**KIRKLEES METROPOLITAN COUNCIL
INVESTMENT & REGENERATION SERVICE**

DELEGATED DECISION TO DETERMINE PLANNING APPLICATIONS

Reference No: 2017/62/93316/E
Site Address: 5, Harewood Grove, Heckmondwike, WF16 0DD
Description: Erection of two storey side and rear extension
Recommending Officer: Olivia Roberts

Officer Report

Ground floor plan

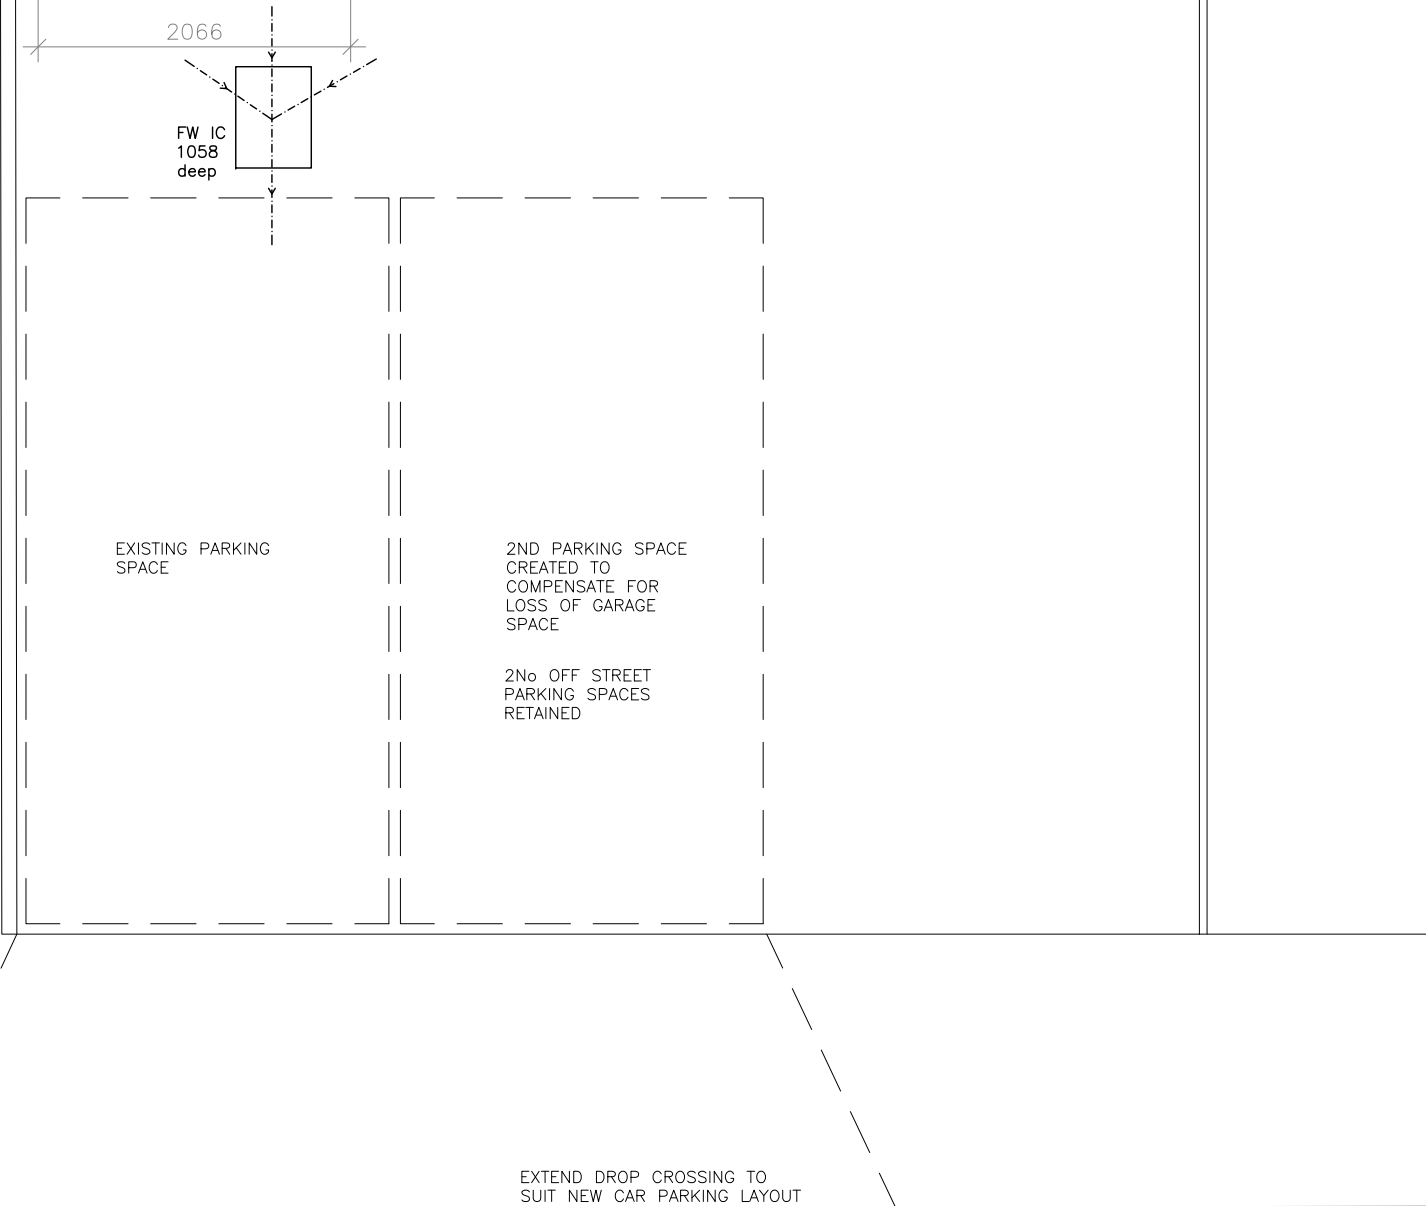
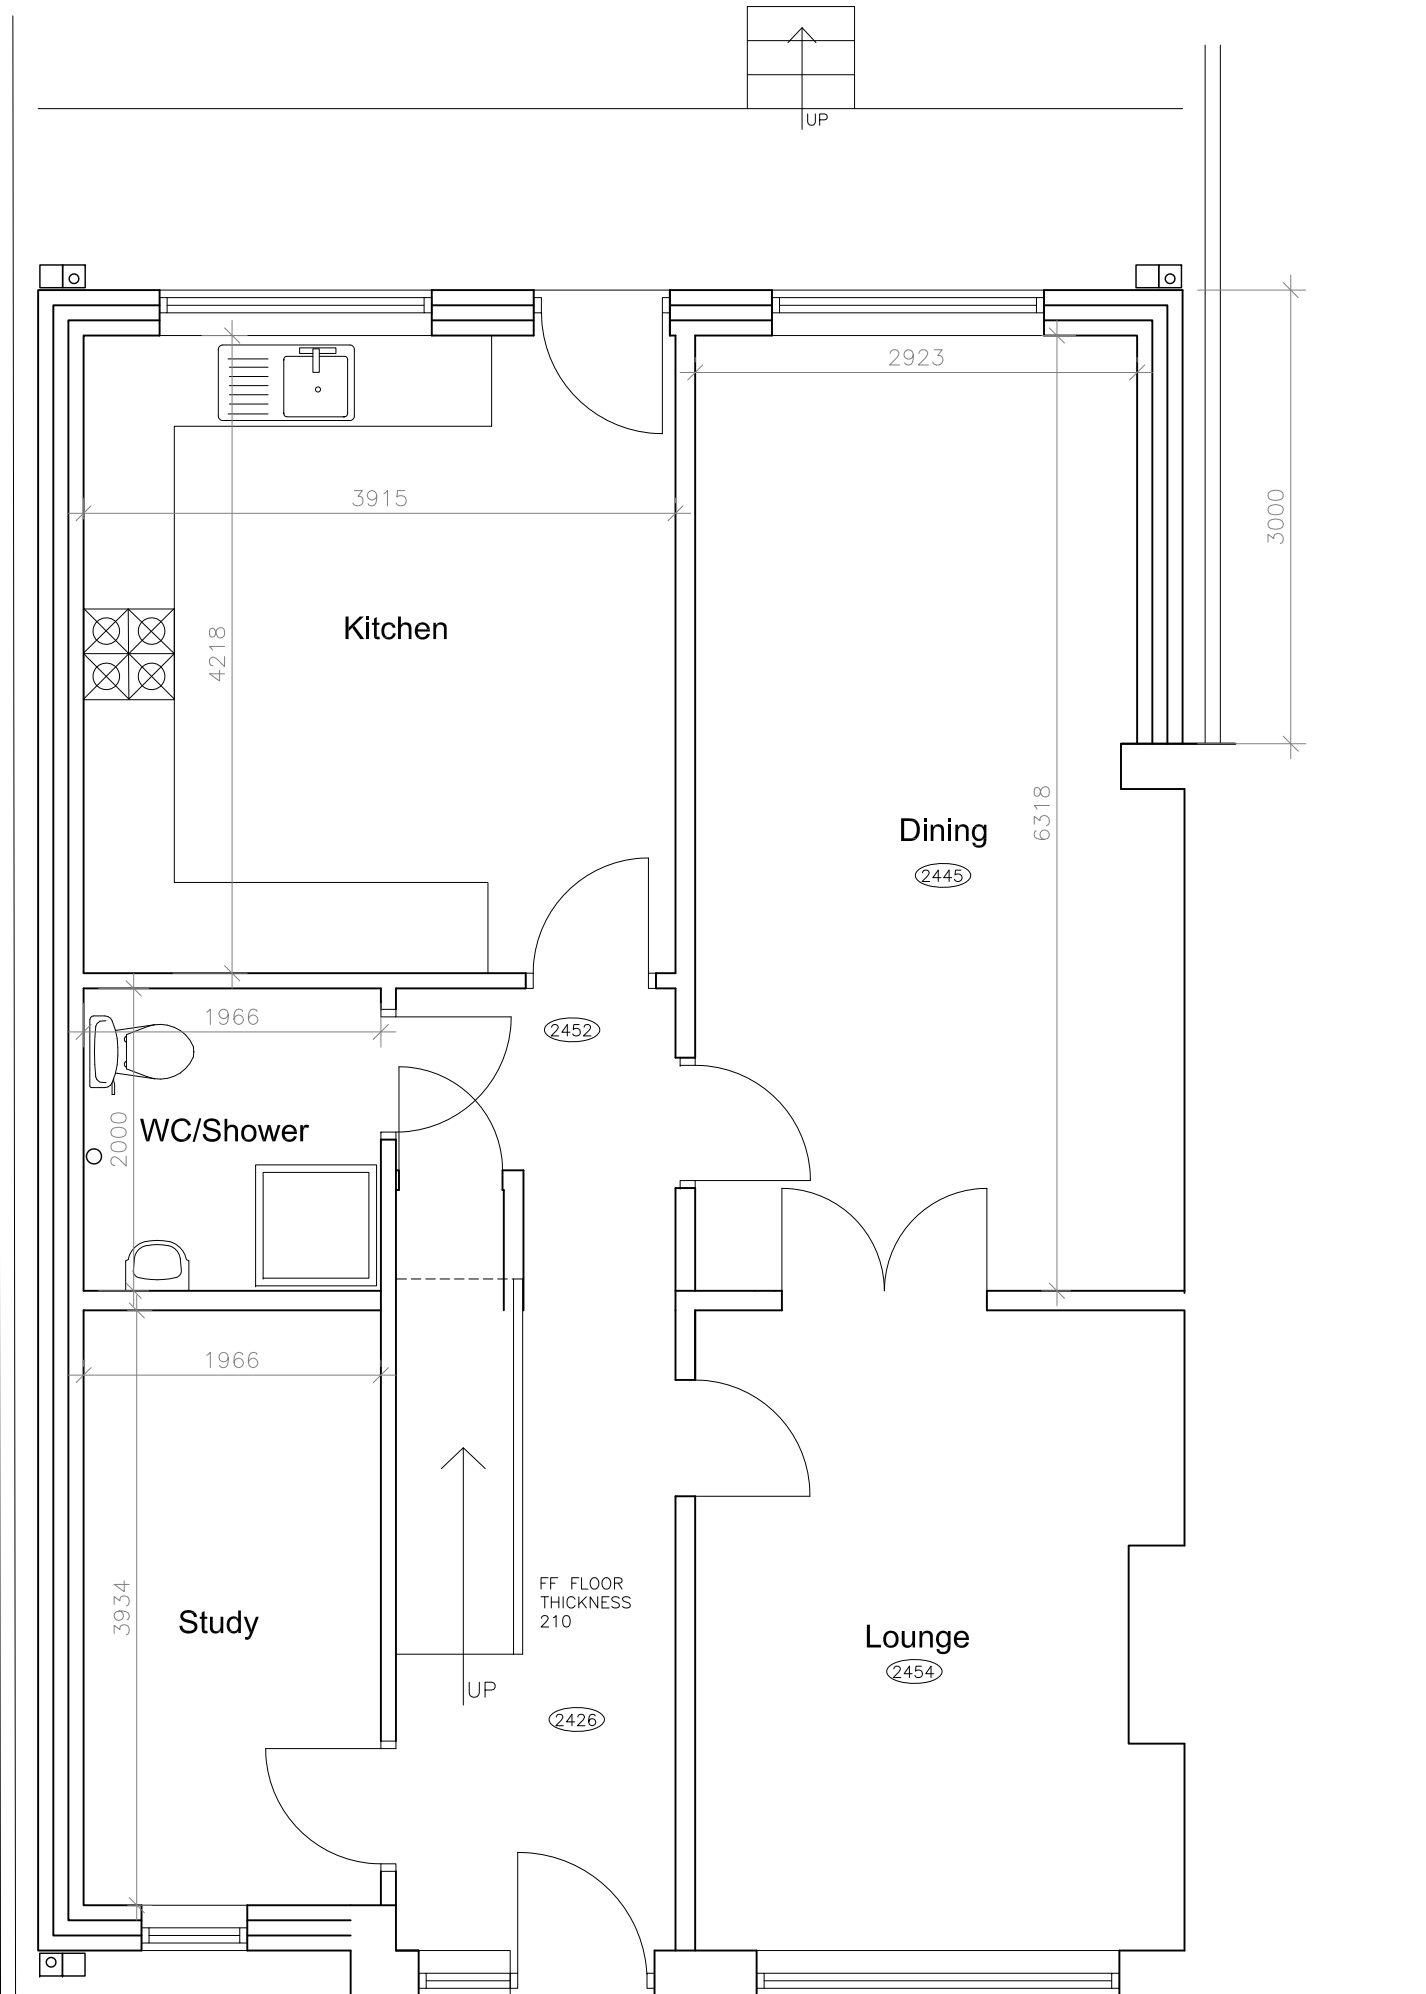
The plans show the creation of an additional off-street parking space which will compensate for the loss of the existing parking space that will be lost due to the demolition of the existing garage. The proposed off-street parking space will be located in the existing front garden area of the property and will involve the extension of the dropped curb to allow for the new parking layout.

Due to the proposal resulting in the loss of a currently off-street parking space due to the demolition of the existing garage to allow for the proposed extensions, there is the potential that the development could have an impact on highway safety. The plans show the creation of an additional off-street parking space which will be located in the front garden area of the property. This would include the removal of a section of the existing boundary wall and the extension of the drop crossing. K.C. Highways Development Management was informally consulted over the suitability of the plans and note that they have no objections to the proposal. The proposal is therefore considered to comply with policies T10 and T19 of the UDP.

5. Prior to the development being brought into use, the approved vehicle parking areas shall be surfaced and drained in accordance with the Communities and Local Government; and Environment Agency's 'Guidance on the permeable surfacing of front gardens (parking areas)' published 13th May 2009 (ISBN 9781409804864) as amended or superseded; and thereafter retained.
